Permit Number: 081397

has permission to Apartment Remodel

AT 20 HILL ST City of Portland ID: 054 C001001

Proposed Use: 2 Family Home - Apartment remodel	Proposed Project Description: Apartment Remodel
--	--

SP.1

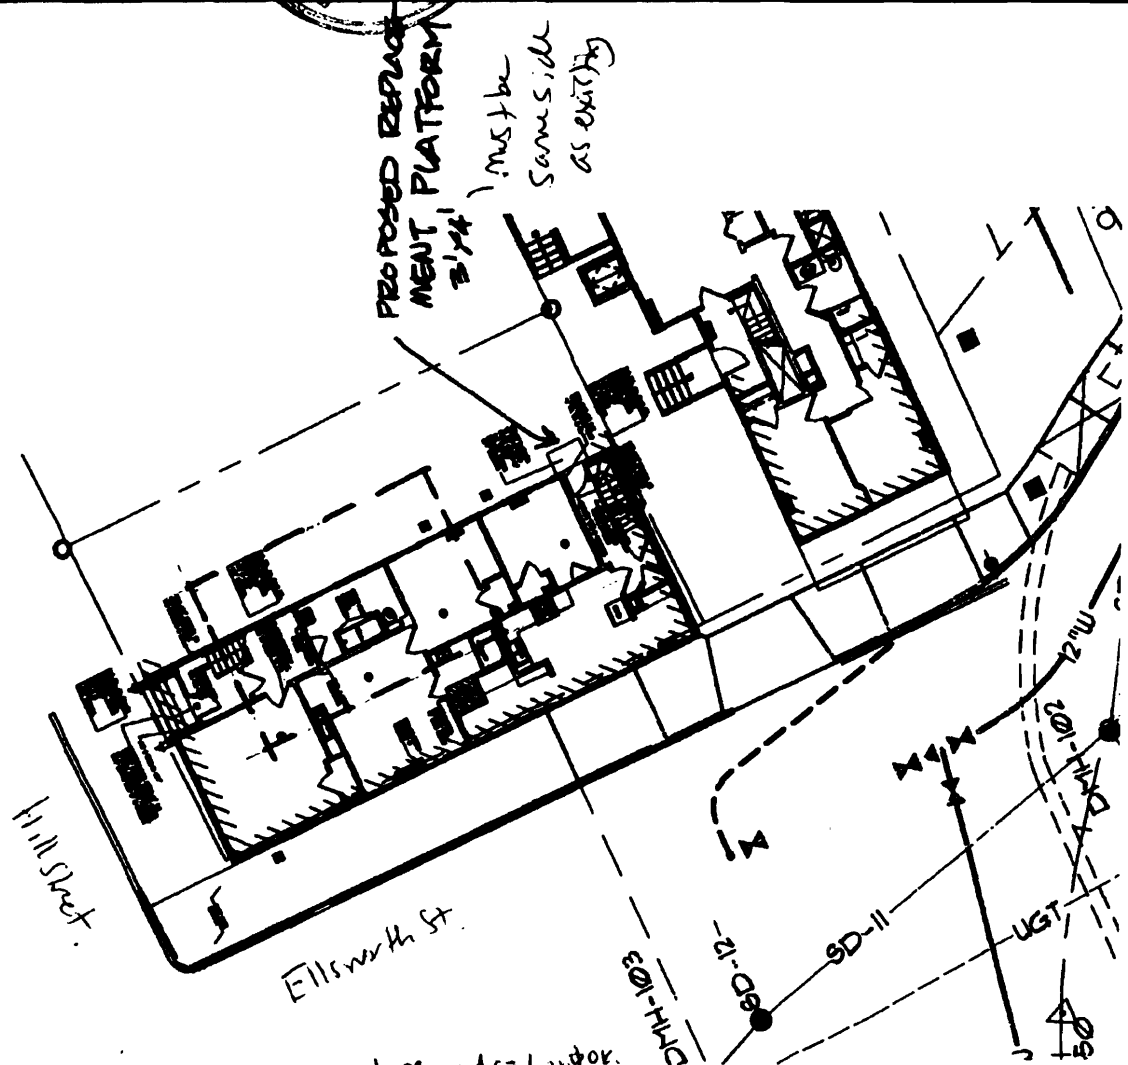
Comments: 11/3/2008-amachado: Left message for Peter Bass. Is replacement platform on the left rear side same size as existing? Does not appear to be.
--

Must be same side as existing
